Online Comment

Application	H02-1272-21
Location	THE ROYAL BRITISH LEGION CHAPEL STREET CROWLAND PE6 0AR
Proposal	Change of use from British Legion Club to child nursery, function halls and 3 flats above

Name	Ian Marshman, Historic Environment Officer
Address	Lincolnshire County Council Lancaster House 36 Orchard Street LN1 1XX

DRAWING
Proposed Elevations
Scale 1:100 @ A1 size
drawing number
211276-09

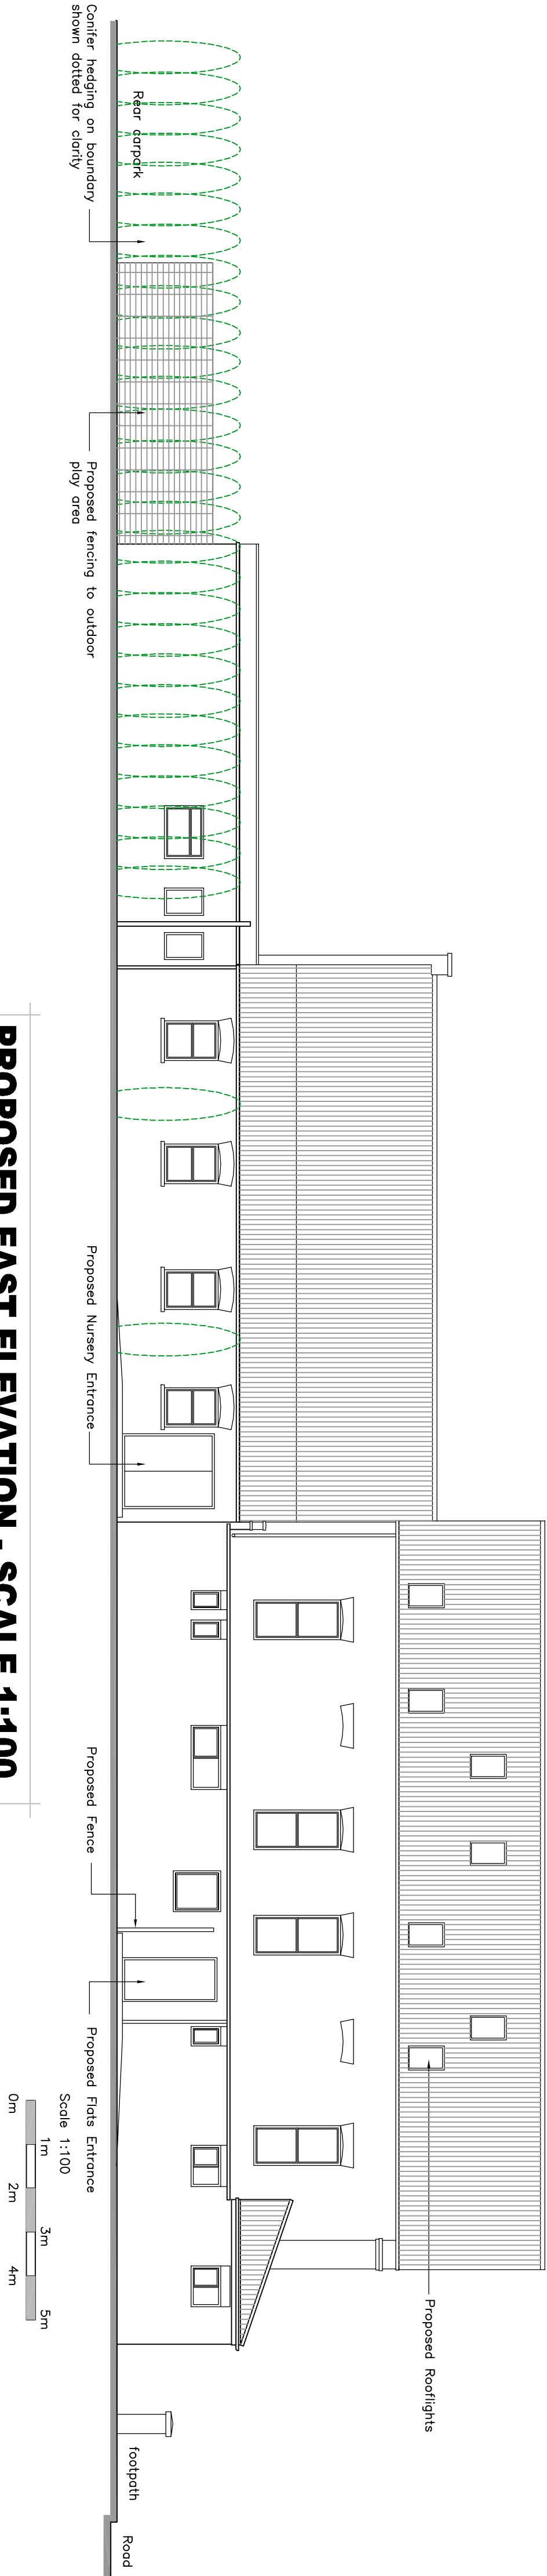
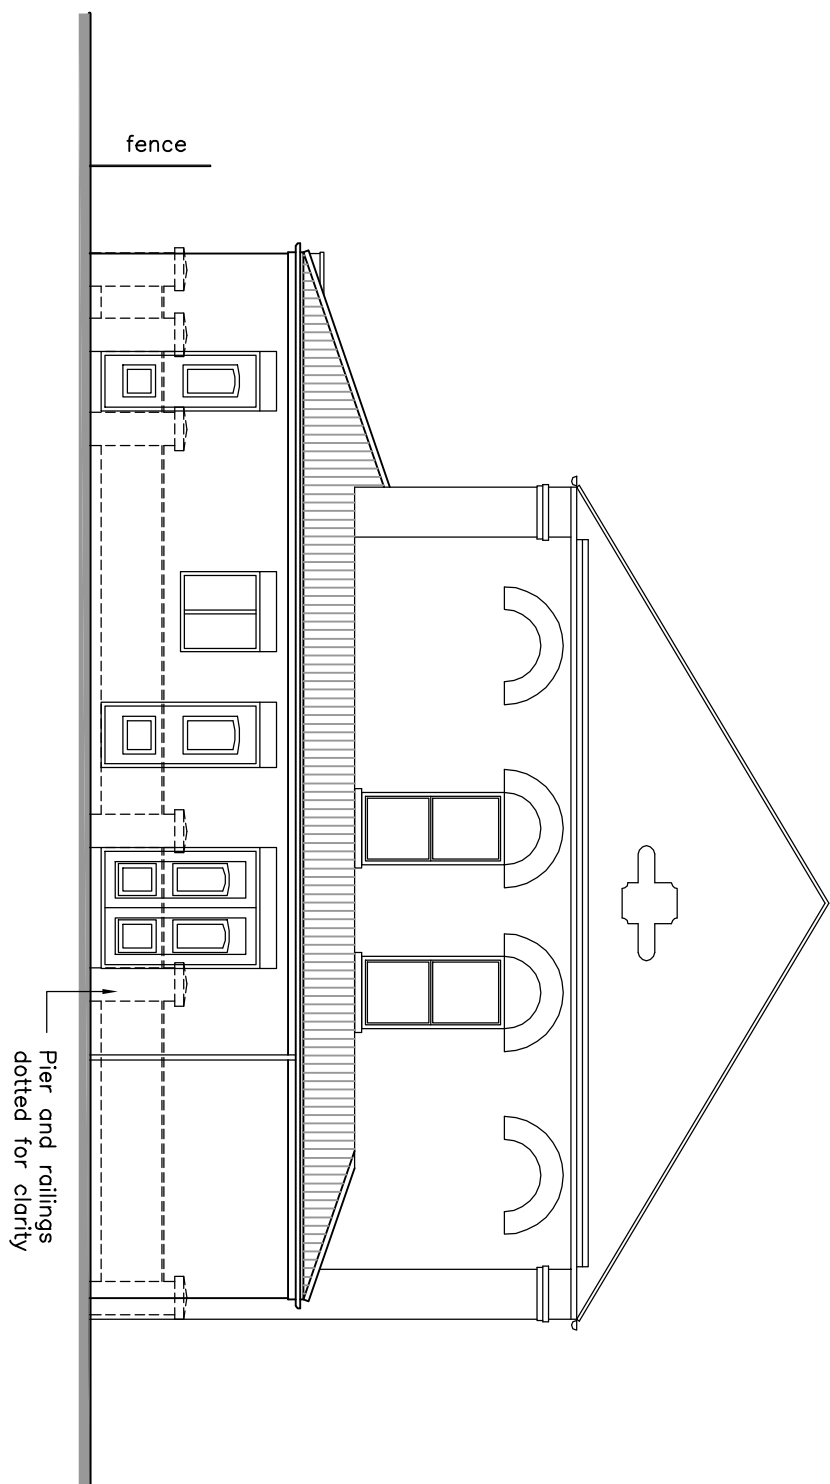
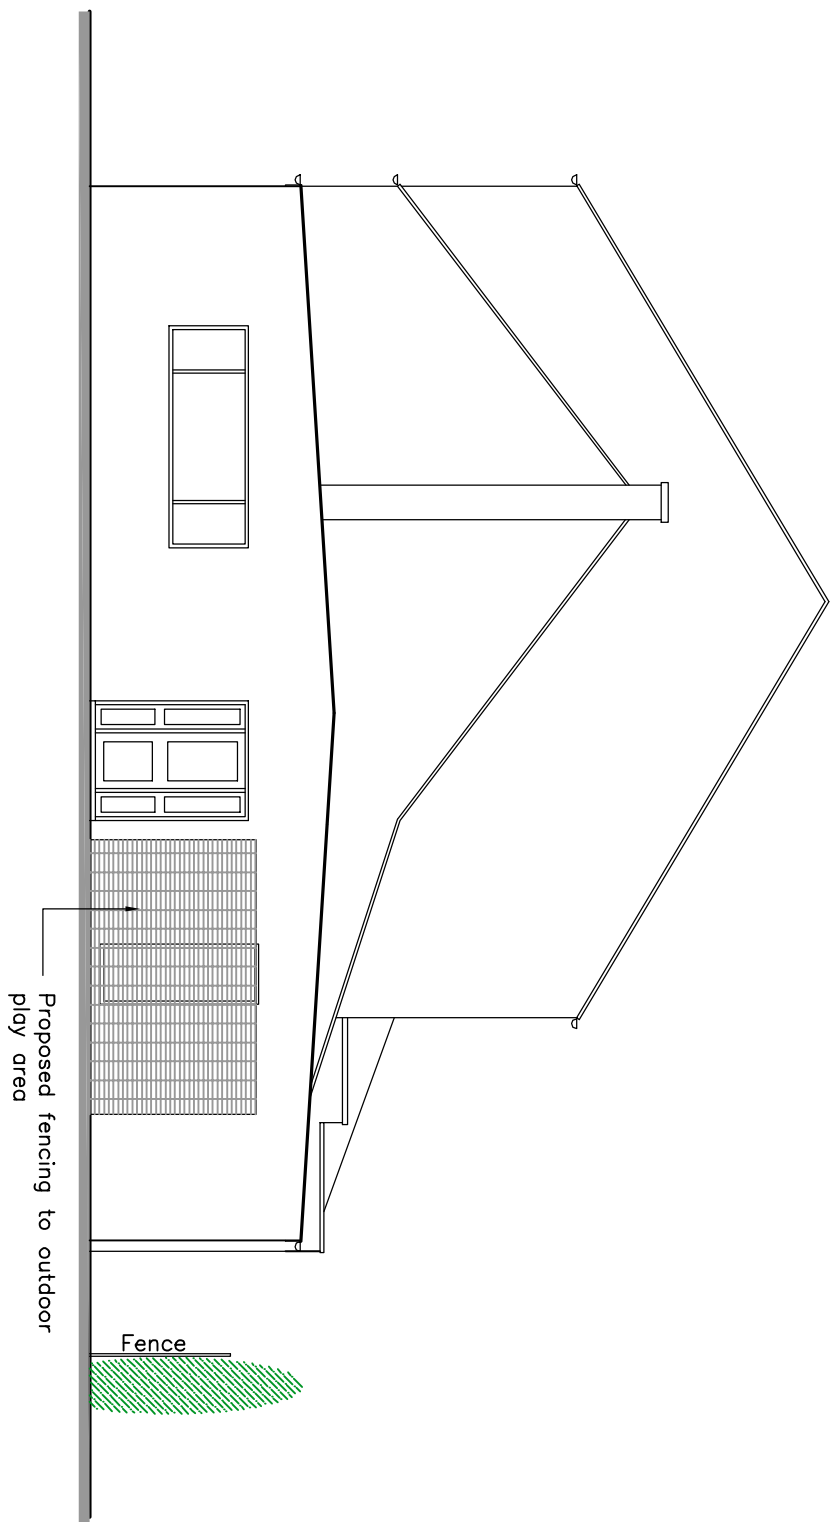
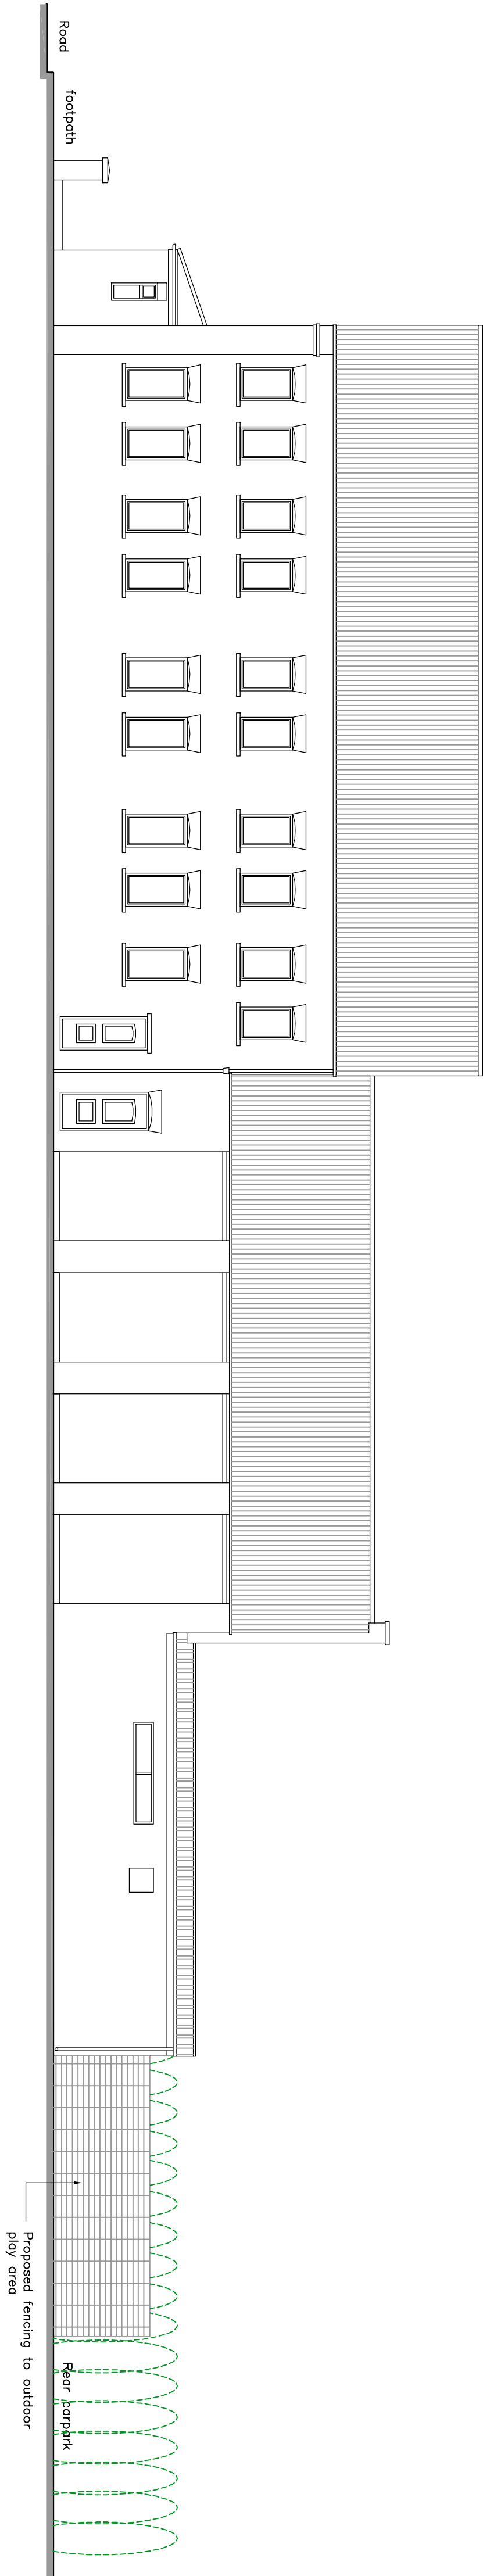
As the building's significance has not been considered in the proposed development there may be the potential opportunities to enhance and better reveal its significance, such as by reopening existing blocked window openings. It is therefore recommended that the developer consult the Local Planning Authority's Conservation Officer to explore this.
